Report of the Head of Planning, Transportation and Regeneration

Address 80 RYEFIELD AVENUE HILLINGDON

Development: Erection of a single storey rear extension, which would extend beyond the rear wall of the original house by 4.00 metres, for which the maximum height would be 3.00 metres, and for which the height of the eaves would be 2.85 metres

LBH Ref Nos: 77317/APP/2022/1731

Proposed Elevations

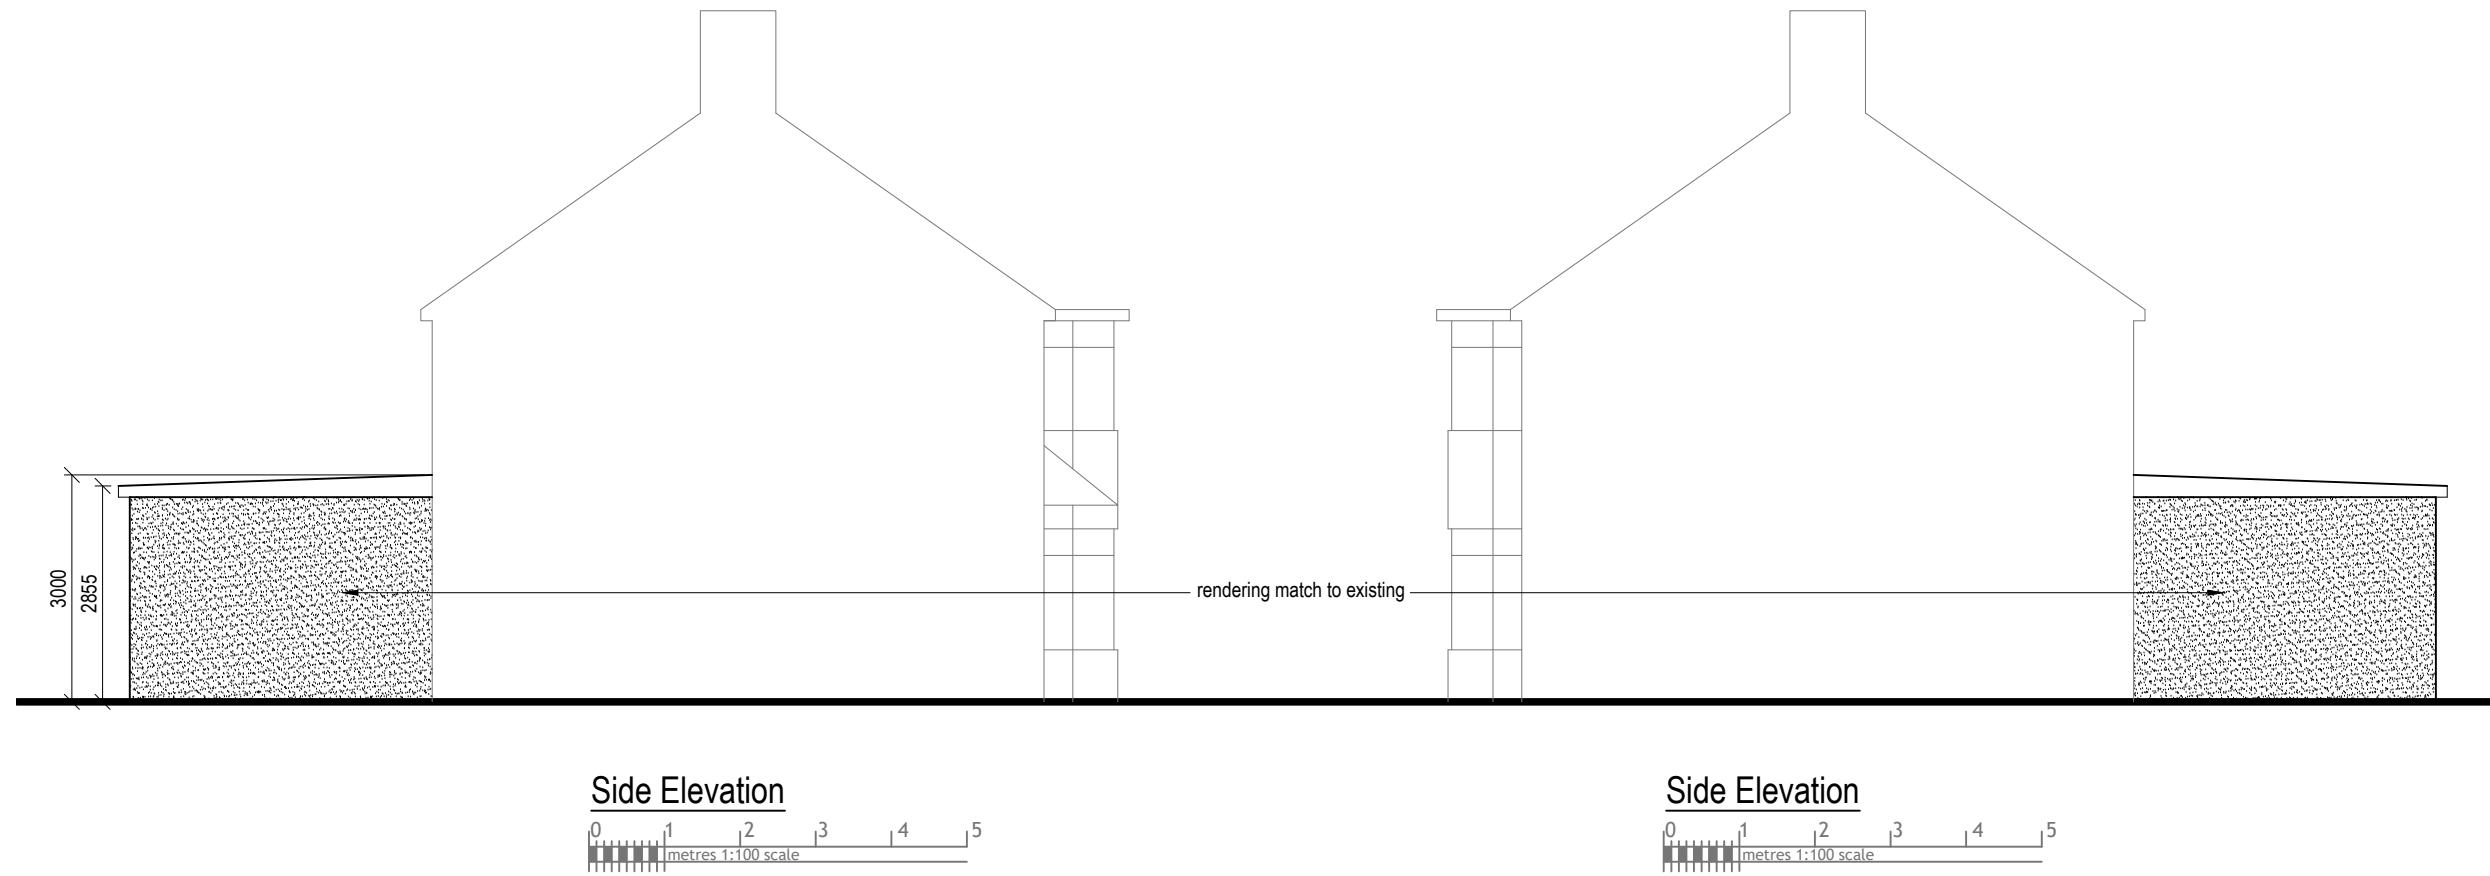
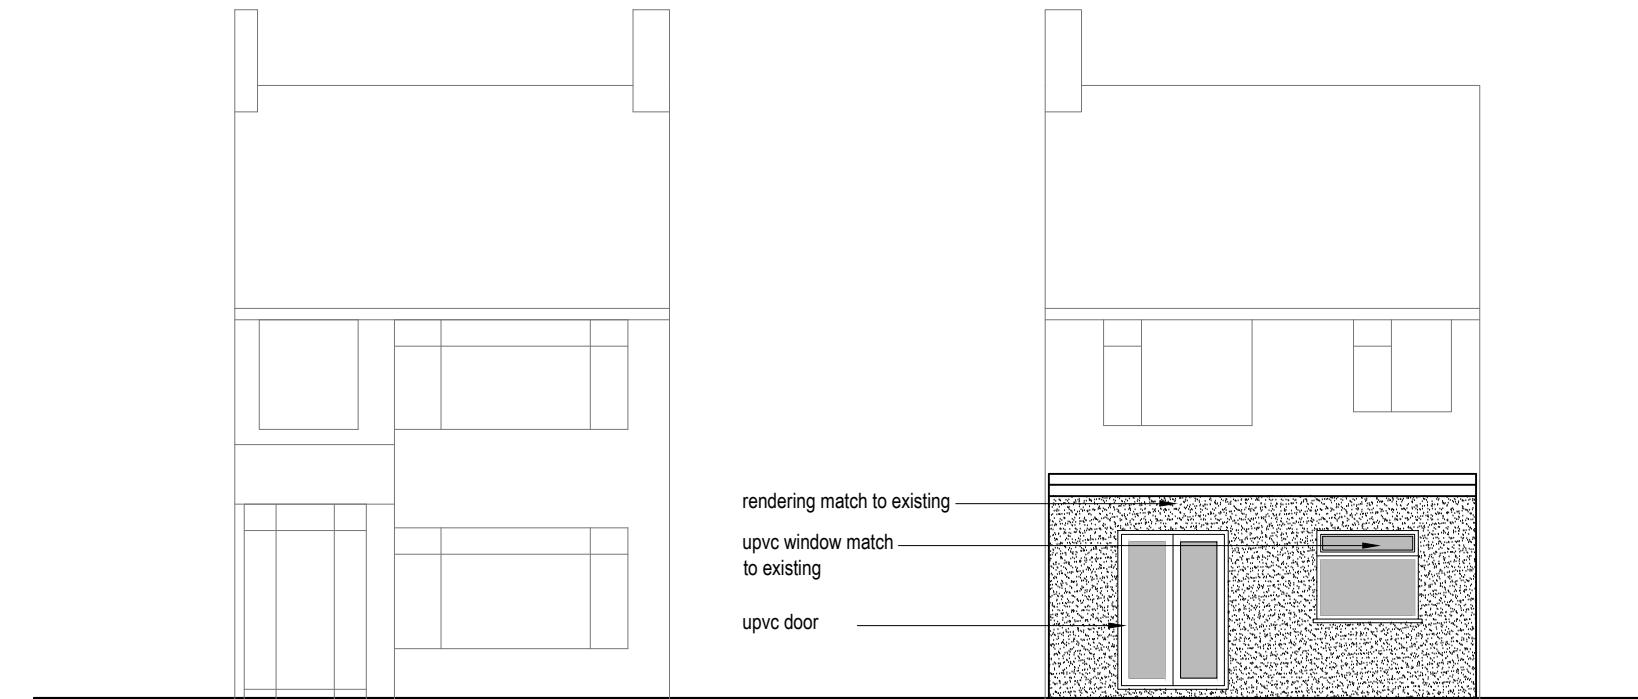
The proposed single storey rear extension would extend beyond the original rear building line by 4 metres with a maximum height of 3 metres, and for which the height of the eaves would be 2.85 metres.

Existing & Proposed Ground Floor Plans

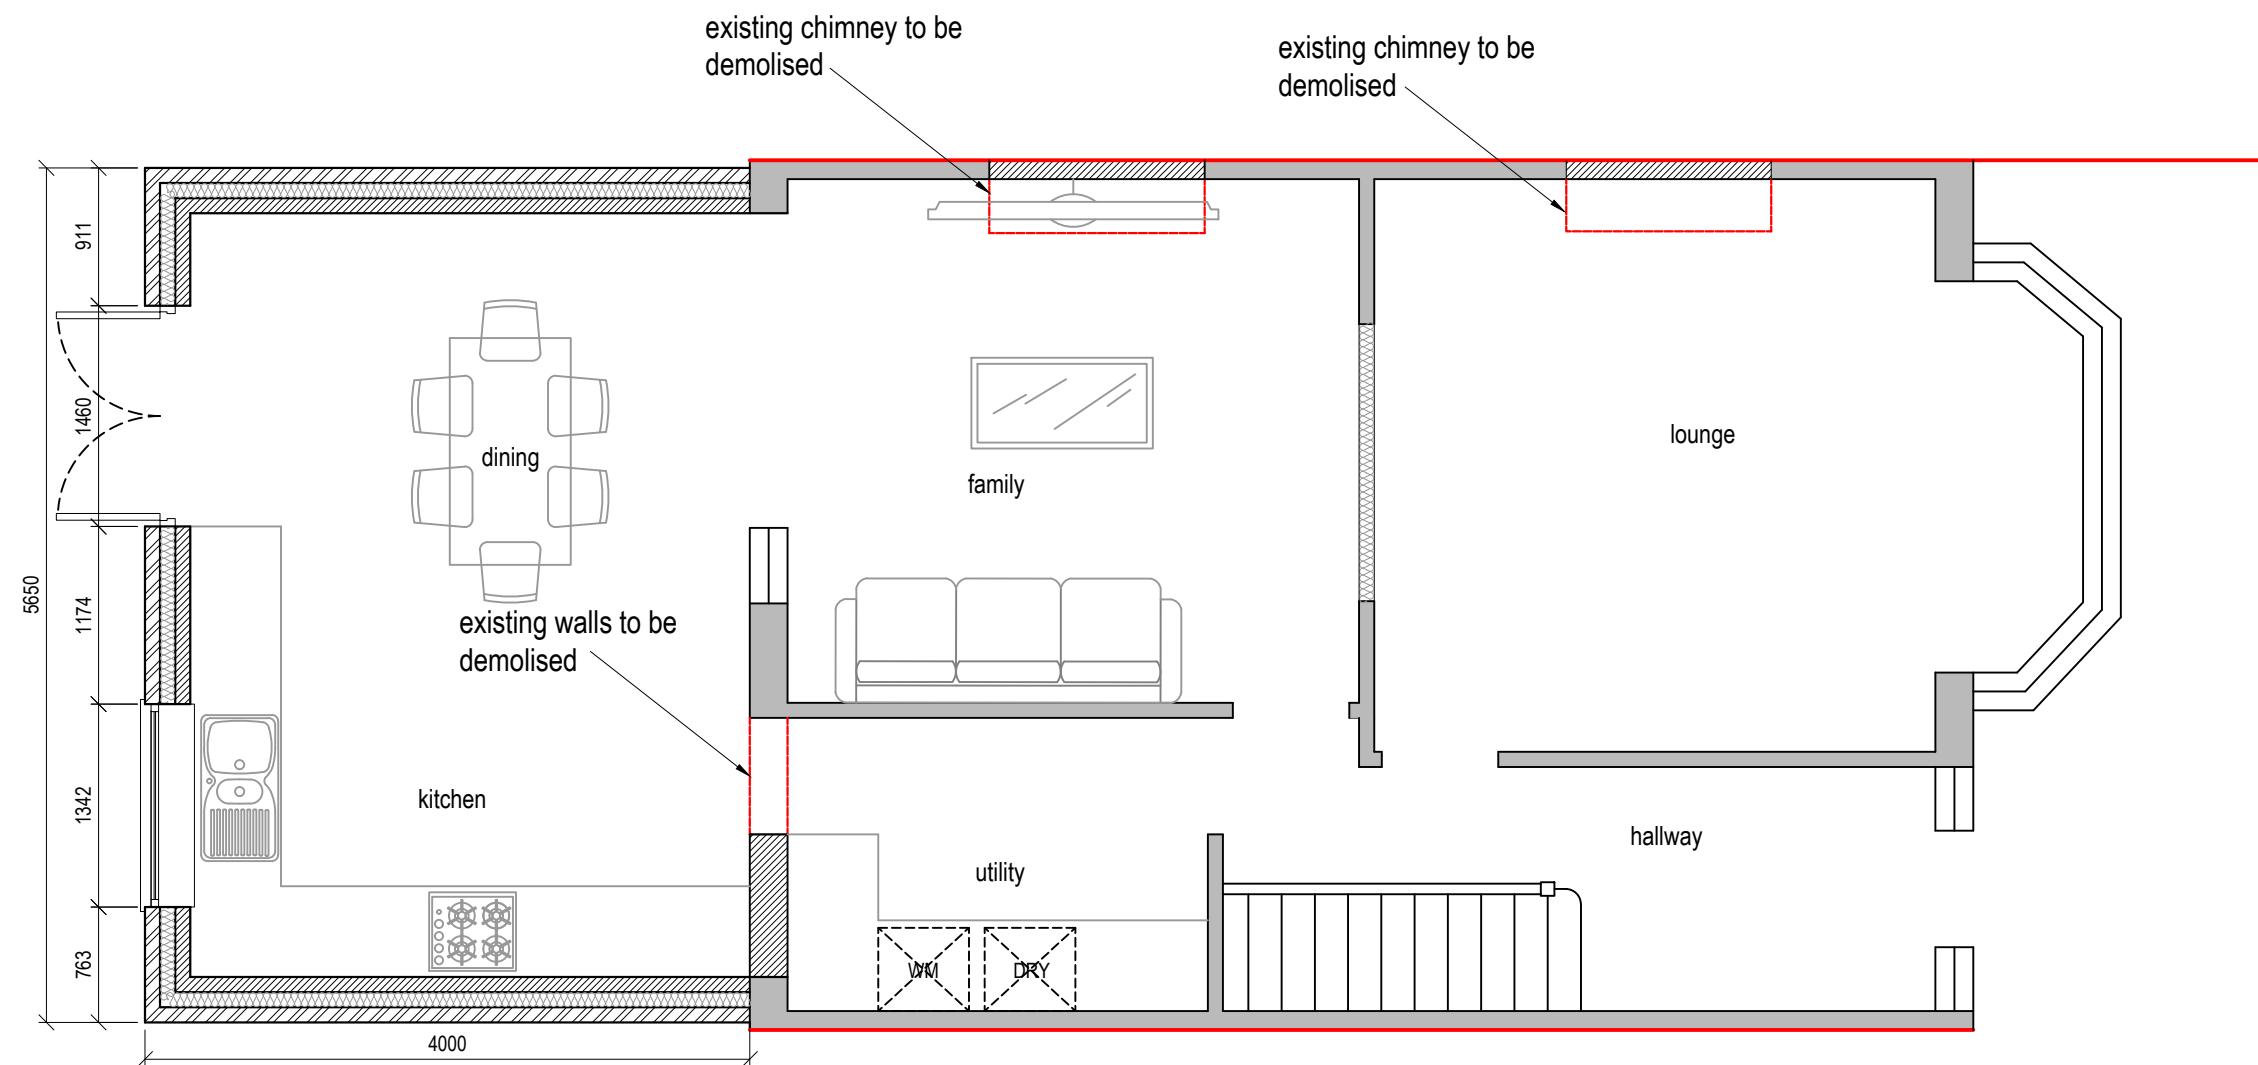
No.78A Ryefield Avenue is located west of the application site. The property benefits from a single storey rear extension measuring approx. 3m in depth. The proposed extension would therefore extend a further 1m beyond the existing rear building line of No.78A. Having regard to the proposed depth beyond the existing rear building line at No.78A (1m) coupled with the modest height of the proposed extension, it is considered that the proposed development would not cause any significant harm to the residential amenities of the neighbouring property in terms of visual intrusion, overdominance, overshadowing, loss of daylight, loss of sunlight and loss of outlook.

No.82 Ryefield Avenue is located east of the application site. The property benefits from a single storey rear extension measuring approx. 3.9m. The proposed extension would extend a further 0.1m beyond the rear building line of No.82. Having regard to the proposed depth beyond the existing rear building line at No.82 (0.1m) coupled with the modest height of the proposed extension, the proposed extension would not cause any significant harm to the residential amenities of the neighbouring property in terms of visual

Due to the separation distance between the host property and the rear building line of No.113 Windsor Avenue, the proposed extension would have no adverse impacts on the neighbouring amenity of this adjoining property.

It is considered that the proposal would not cause unacceptable harm to the residential amenity of neighbouring residents at Nos 78A and 82 Ryefield Avenue and 113 Windsor Avenue. Accordingly, the submission is recommended for approval.
